I am extremely disappointed to have received the attached refusal notice following our resubmission of surface water drainage information in relation to condition 6 of outline planning permission BN/32/15/OUT.

Application No: BN/86/21/DOC
Registered: 23rd June 2021
Site Address: Land Rear of Lillies Yapton Road Barnham PO22 0AY
Grid Reference: 496408 104092
Description of Works: Approval of details reserved by condition imposed under ref BN/32/15/OUT relating to Condition No 6 - surface water drainage.

Town & Country Planning Act 1990 (as amended)
Town and Country Planning (Development Management Procedure) (England) Order 2015
Approval of details reserved by condition imposed under ref BN/32/15/OUT relating to Condition No 6 -
surface water drainage.
Land Rear of Lillies Yapton Road Barnham PO22 0AY

17748-BARN-5-SK003 C

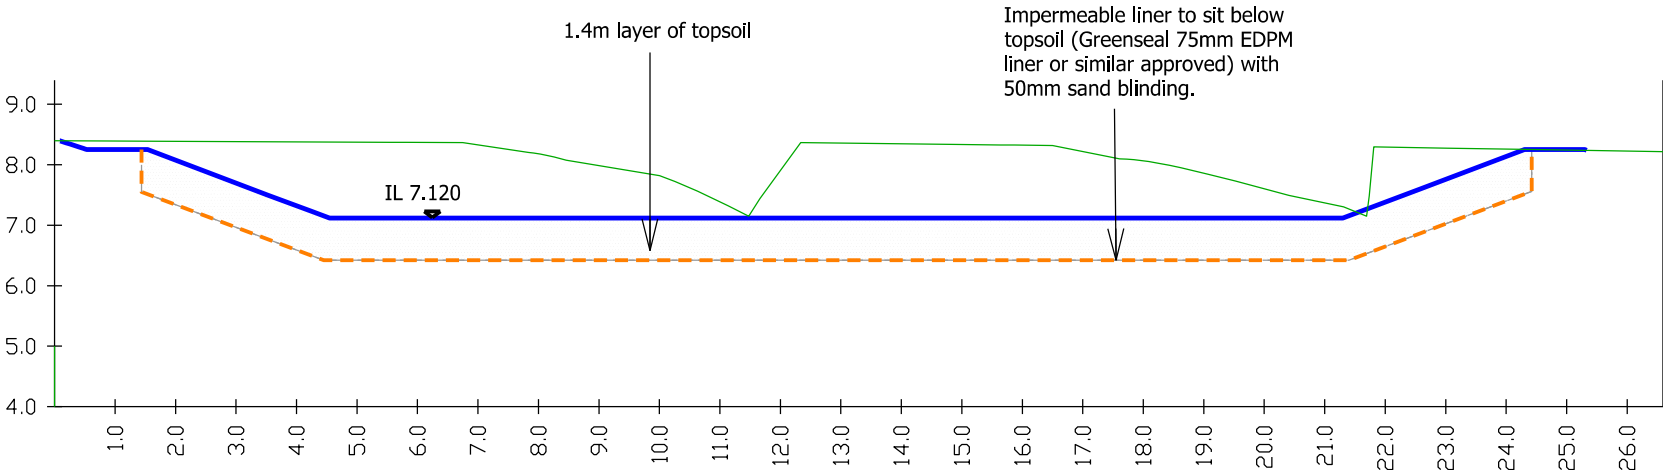
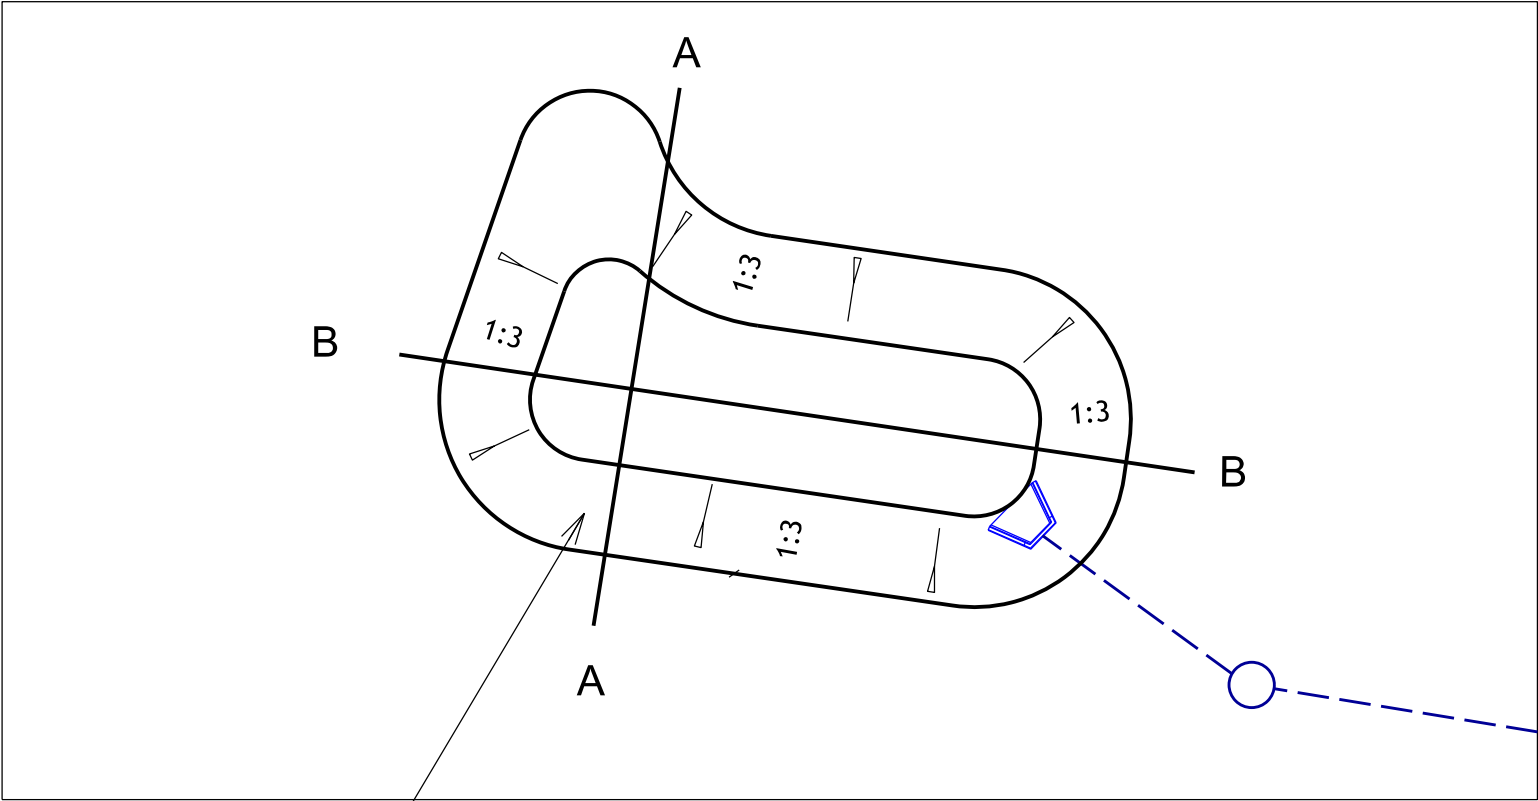
Condition 6 was previously discharged under BN/129/20/DOC. Although no covering note has been provided on the portal for this application it appears that the applicant is looking to alter the basin design only as part of this new application.

The groundwater monitoring data supplied as part of this application does not include any monitoring completed at the location of the proposed basin. It is also noted that half of the monitoring boreholes were deemed to have been impacted by onsite dewatering activities. Monitoring was not completed over the full winter with no data provided between mid-December and mid-February. As a result of these factors it is deemed that the groundwater monitoring results presented cannot be relied upon. The design approved under BN/129/20/DOC is still suitable.

The groundwater monitoring data submitted as part of this application to alter the basin design does not include any monitoring completed at the location of the proposed basin. It is also noted that half of the monitoring boreholes were deemed to have been impacted by on-site dewatering activities. Monitoring was not completed over the full winter with no data provided between mid-December and mid-February. As a result of these factors it is deemed that the groundwater monitoring results presented cannot be relied upon. Without adequate monitoring it has not been evidenced that the revised design would not increase on site or off-site flood risk for the duration of the development, contrary to Policy W DM2 of the Arun Local Plan.

Condition 6 was previously discharged under BN/129/20/DOC; and the basin design approved under BN/129/20/DOC is still suitable.

1. The location of Monitoring Position 4 is within 10-15m of the proposed pond, is topographically at the same level, and any change in groundwater levels over that distance would be negligible. The reason for the positions of the monitoring locations over the whole site was to ensure an even coverage.
2. The dewatering has not affected Monitoring Position 4 (this is stated within the results) and a robust set of monitoring over the winter months was obtained (6 readings between 2/11 and 16/3/2021). The readings of 14/12/2020 and 16/2/2021 indicate a 100mm difference between them and whilst no reading was obtained in January 2021 (due to in place covid related restricted travel arrangements), it is not unreasonable to extrapolate a similar reading in January to those of December and February
